RE: Deadline 3 submission by Hampshire County Council in respect of the application by AQUIND Limited for an order granting Development Consent for the AQUIND Interconnector Project

Appendix One - Highway Authority Response to Deadline 3

Comments on Aquind's Response to Hampshire County Council's Local Impact Report (LIR)

**Plate 5 – Typical Schematic of Joint Bay (distances in millimetres)**

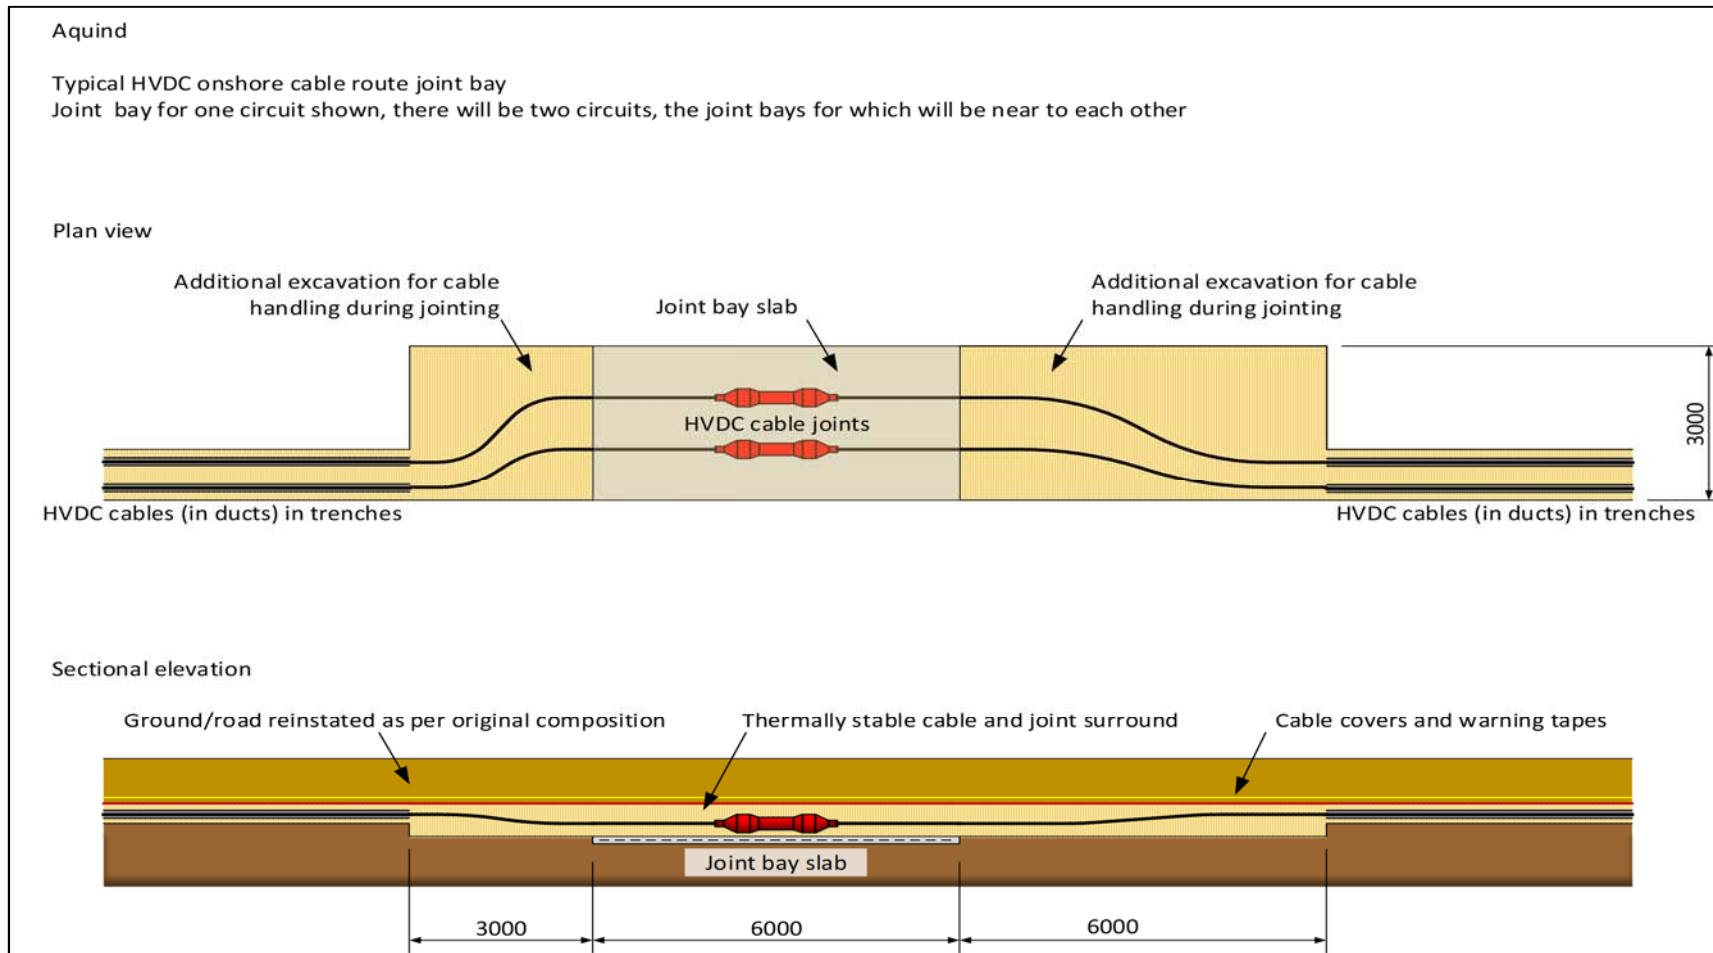
The Highway Authority are still concerned regarding the locations of link boxes and joint bays, especially given the size of the construction areas required for the joint bays and the overall size of the bays themselves.

The response received from the applicant at deadline 2 has provided no further clarity on this matter. It is unclear what level of approval the Highway Authority will have over the locations of these elements of the infrastructure. The Highway Authority would wish to reserve the ability to refuse permission for any locations within the highway when the detailed proposals are put forward by the applicant if, for example, it would preclude future highway

works or raise a highway safety concern (such as obstruction of visibility splays by link boxes). In the absence of this provision, the detail of the link boxes and joint bays should be provided at this stage of the consent process so the impacts of the scheme can be assessed in appropriate detail.

The joint bays may require an Approval in Principle (AIP) and it is noted that the applicant is looking to secure this approval process within the protective provisions. The Highway Authority are considering this in more detail and shall discuss further with the applicant.
